Thames Tideway Tunnel
Thames Water Utilities Limited

Thames Water's Response to Local Impact Report from London Borough of Lambeth

Doc Ref: **APP30.08**

1 Response to London Borough of Lambeth Local Impact Report

Figure 1.1 Albert Embankment Foreshore: Site context and location plan

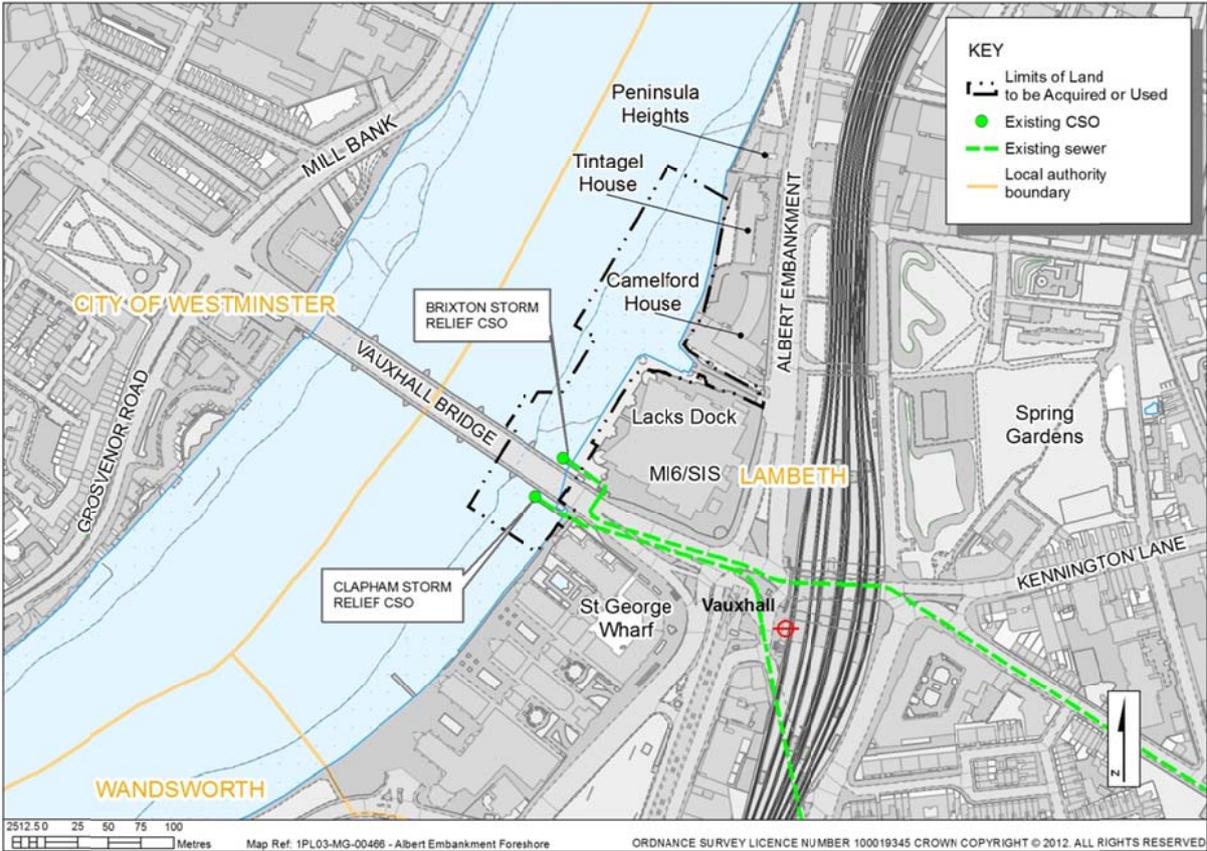
6.	12.41	<i>“In respect of the proposed construction access options the Local Authority would like to make it clear that Option A (utilise Lack’s Dock and existing vehicle cross over to Albert Embankment) is preferred rather than Option B (new access between Camelford House and Tintagel House and associated vehicle cross over to Albert Embankment). The work site adjacent to Vauxhall Cross would have access and egress during low tide only, this method of construction and access would allow uninterrupted access for Duck Tours and other necessary access to the Thames via Lack’s Dock. Furthermore this approach eliminates the likely detrimental effect on Albert Embankment Gardens, the listed Embankment wall and reduces the likely adverse effects on nearby residential neighbour amenity notably with respect to properties at Peninsula Heights. To reiterate the LPA would object to option B.”</i>	We note the council’s submission but have no preference for either option, which will be determined by the Secretary of State. This is a matter of disagreement noted in the SoCG.
